PCU069249

1 February, 2017

Concept Proposal – Harbourside Redevelopment

Image 100 Illustrative Eastern Elevation

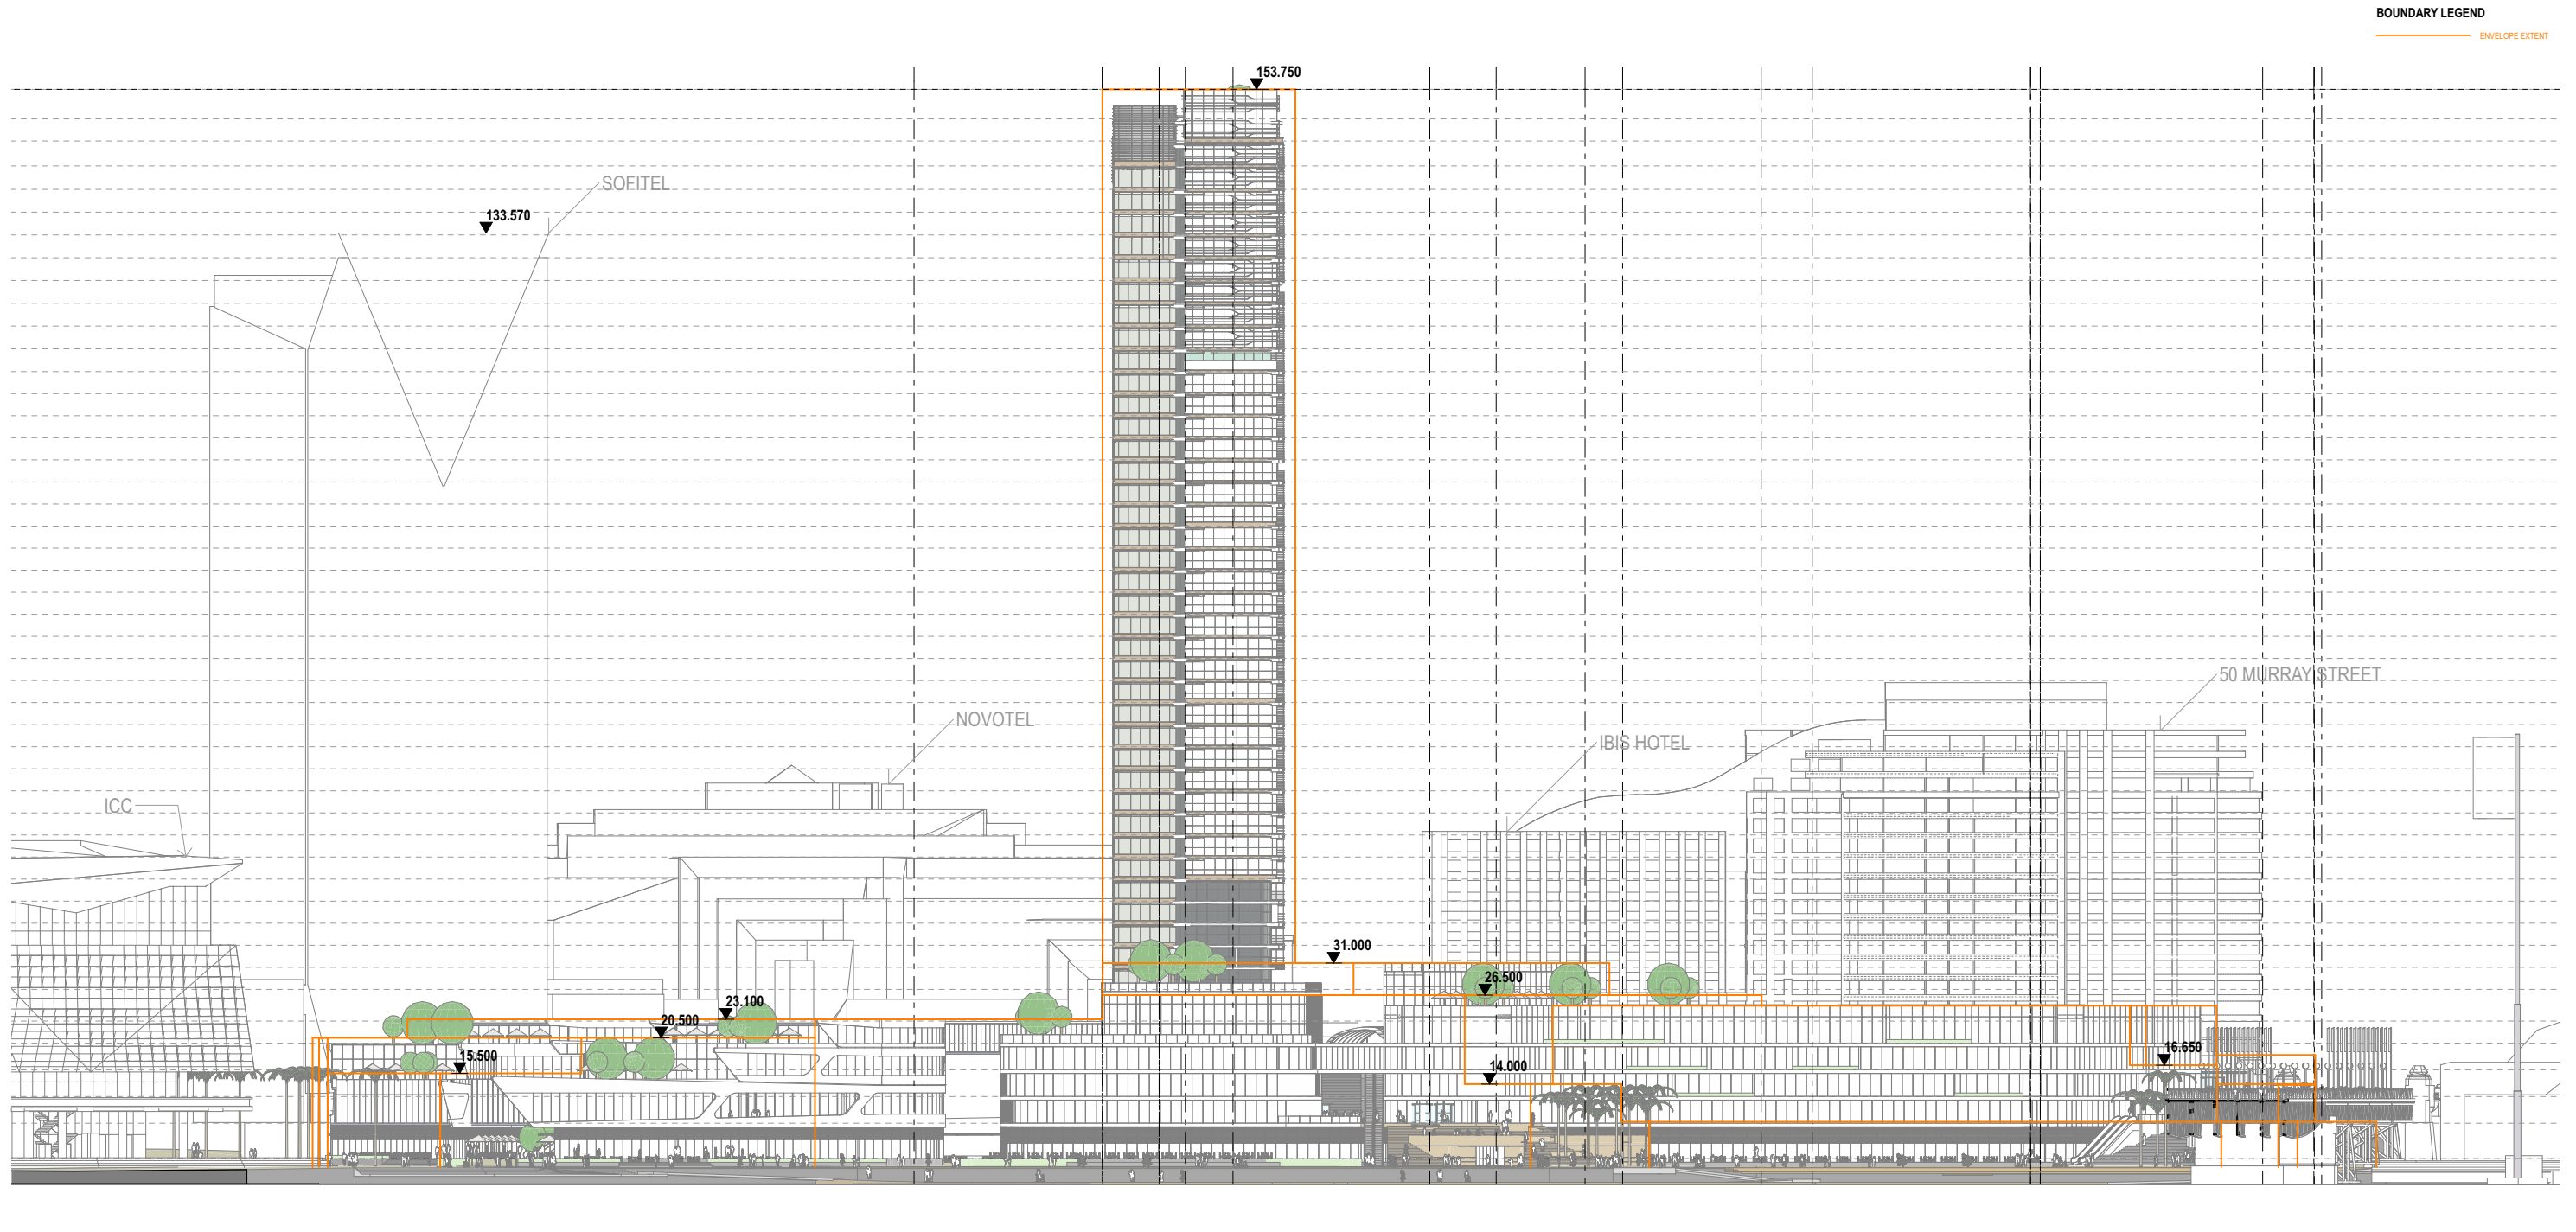
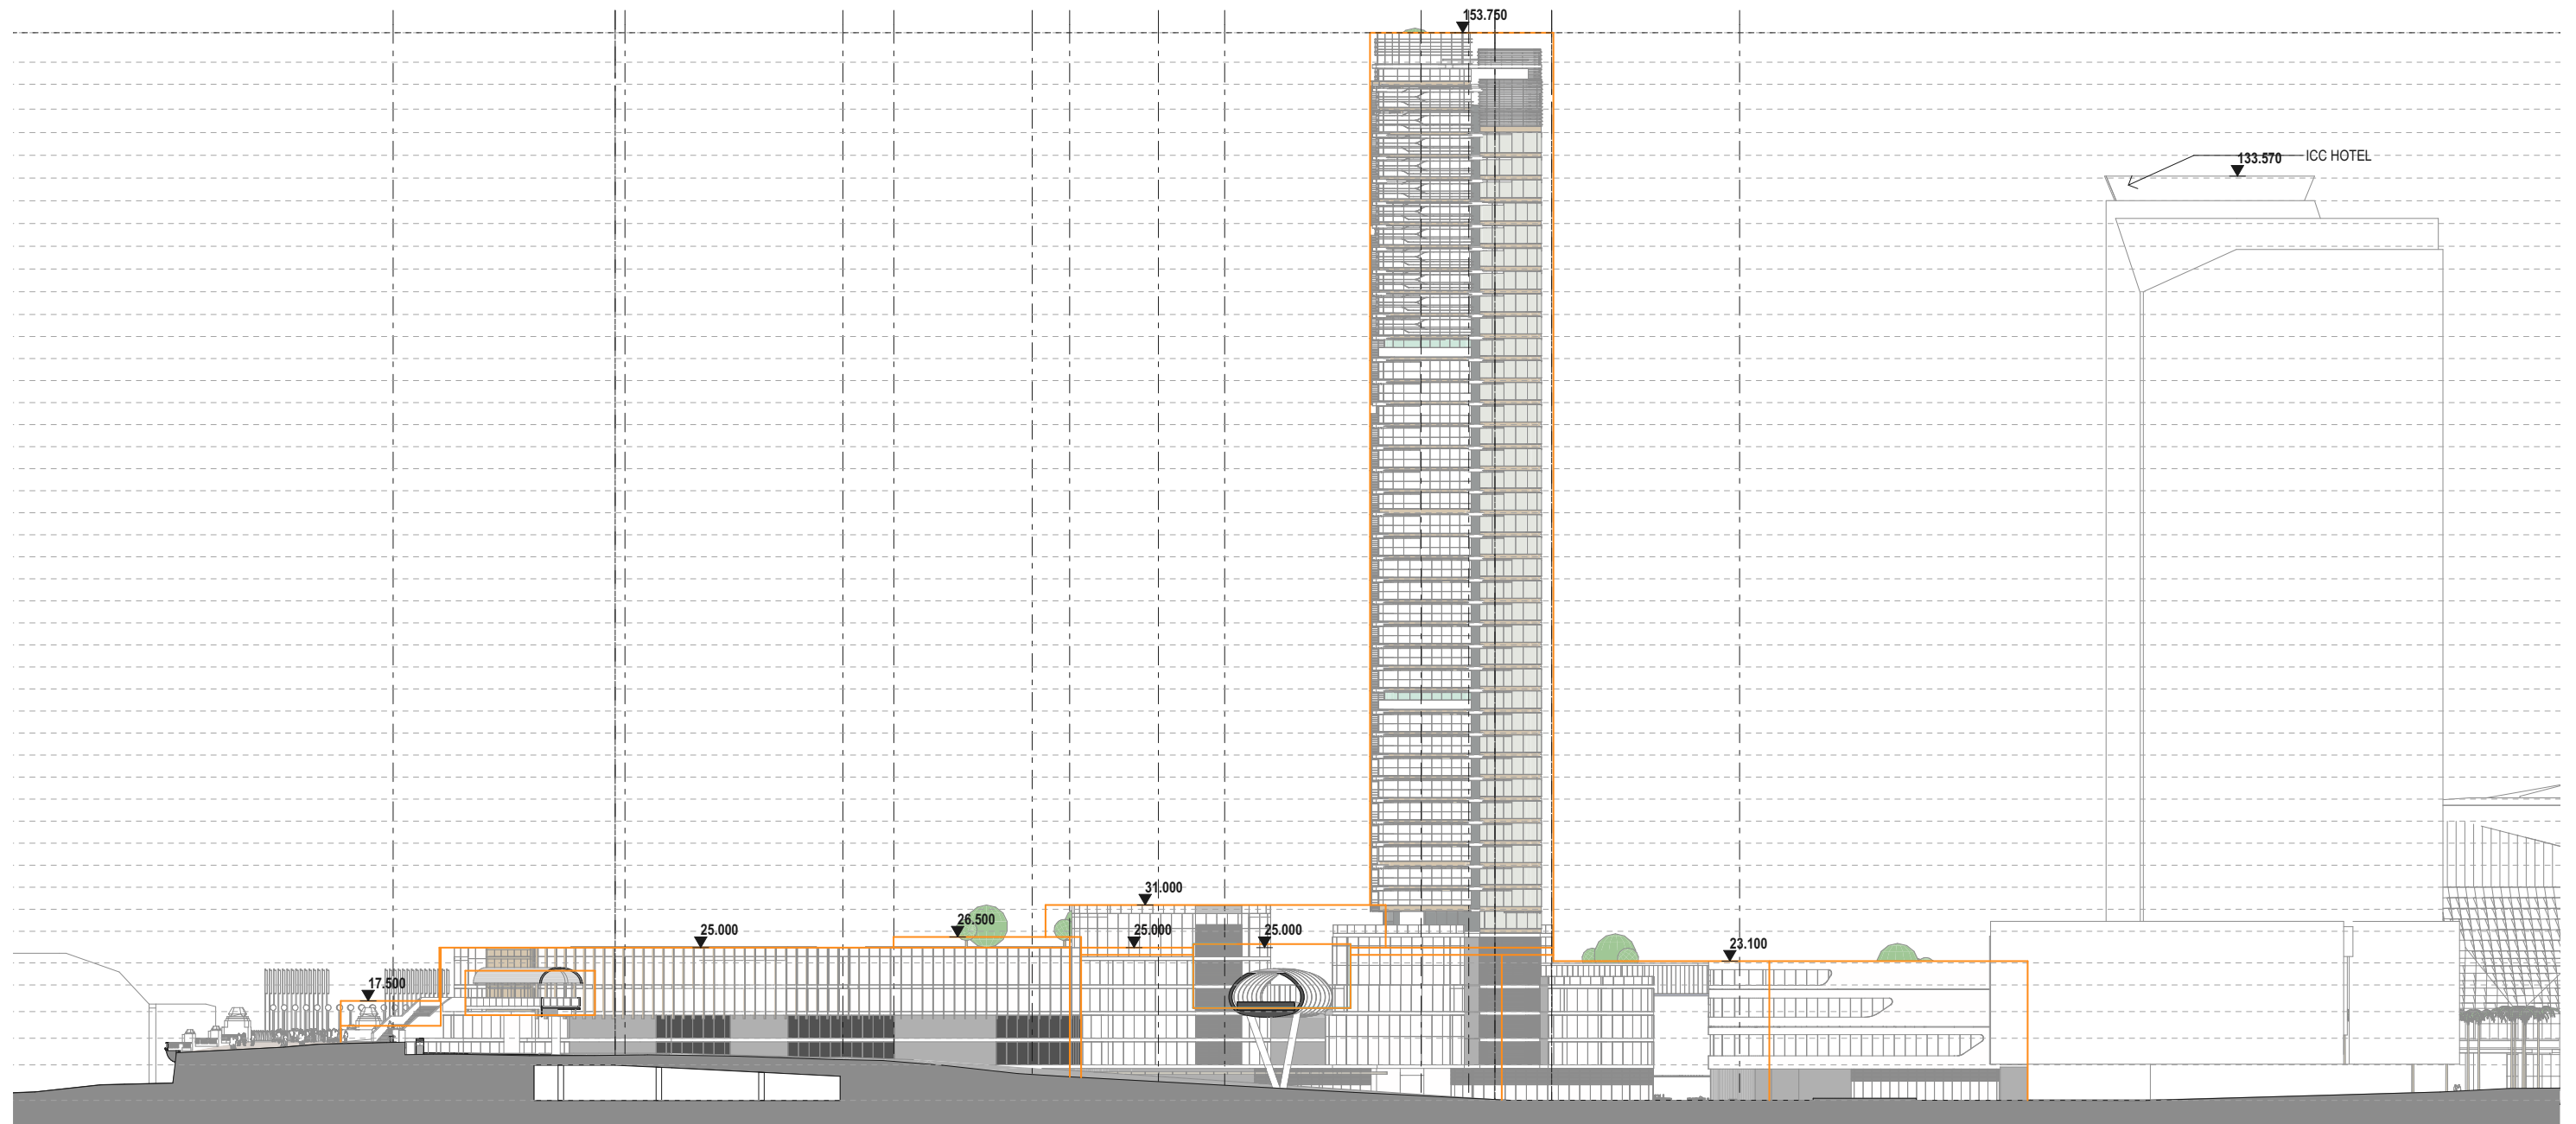
Scale of Project – The building envelope, as presented, enables the construction of flanges to a height of 74.5M which will ensure that the tower will obscure light and views of, and create a wind tunnel affecting many of the east facing apartments in 50 Murray Street and the Ibis Hotel. (See photos below, for views currently enjoyed by residents of 50 Murray Street) Concept drawings depict the residential component as comprising two adjoining towers, resulting in a building of considerable bulk. In addition, the envelope allows heights of up to 30.5M on the retail podium section of the building which will be 6-storeys in height, effectively resulting in a 48-52 storey retail/residential tower block (noting the proponent remains hazy about the eventual height), ten storeys higher than the ICC hotel. We note that stepped forms of both the podium and the flanges result in the highest points being directly in front of 50 Murray Street and the Ibis Hotel.

The building envelope also appears to depict the podium as being much closer to the Pymont Bridge than the existing building, with the stepped platforms being substantially higher than the bridge itself (17.5M to 23.8M) (p55 EIA), unlike the current situation. Pp 55 and 58 of the Architectural design report and drawings appear to depict the podium built OVER the Pymont Bridge. We also note and oppose plans to remove a section of the heritage bridge railing.

Recommendation: The proposed building envelope should be rejected on the grounds that the tower and podium are too high, too close to the waterfront and Pymont Bridge, obscure light and views of nearby residents, overshadow residential buildings in Pymont and the waters of Cockle Bay, and create higher wind velocity. Retain existing heritage bridge railing.
